Project Name : Bilsham Road, Yapton
Job No : 19-326
Note Title : Drainage Strategy and MMP
Author : NA
Checked : GG
Approved : GG
Date : November 2020

1.1 Odyssey has been commissioned by Bilsham Road Development LLP to undertake a surface water and foul drainage strategy as part of a reserved matters application associated with the proposed residential development at Bilsham Road, Yapton.

BILSHAM ROAD, YAPTON			
Drawing Title: PRELIMINARY ENGINEERING LAYOUT. SHEET 2 OF 2			
Client: BILSHAM ROAD DEVELOPMENT LLP			
Scale: 1:500 @A0	Date: FEB 20	Designed: NA	
Drawn: LS	Checked: JH	Approved: GG	
Job No: 19-326	Drawing No: 19-326/010	Rev: J

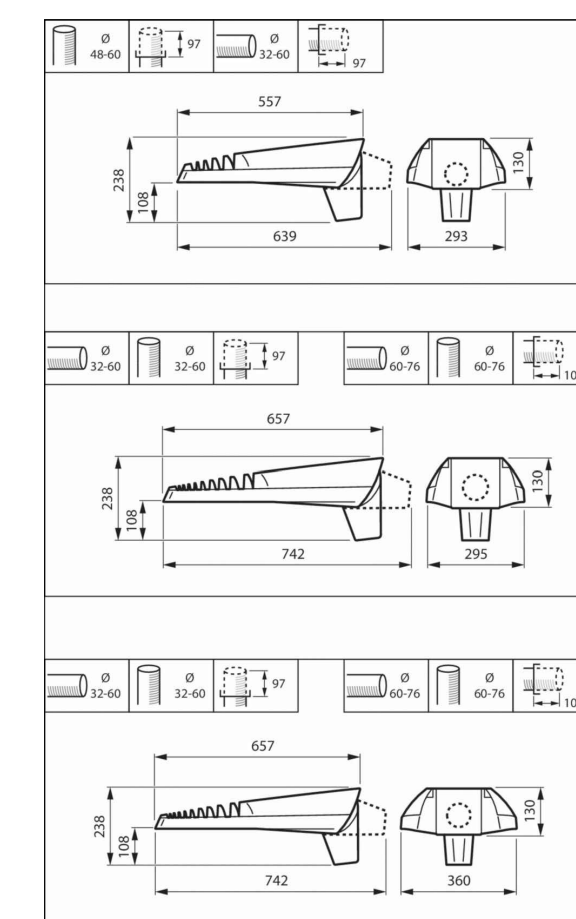
2.8 Initial comments were received from the Principal Drainage Engineer at Arun District Council. A response to these comments can be found below.

1. The permeable paving has been extended to all parking spaces/property driveways
2. All basins have been designed with at least 300mm freeboard
3. To be checked at detailed design
4. Basin 4 has been kept in its previous position. To move this any closer would result in a clash with the flood plain.
5. To be checked at detailed design.

6. Only minimal flooding of 2.8m³ is registered in two manholes. Overland flow routes ensure the excess surface water is kept away from people and property.
7. Typo in section 2.5 of report has been updated.
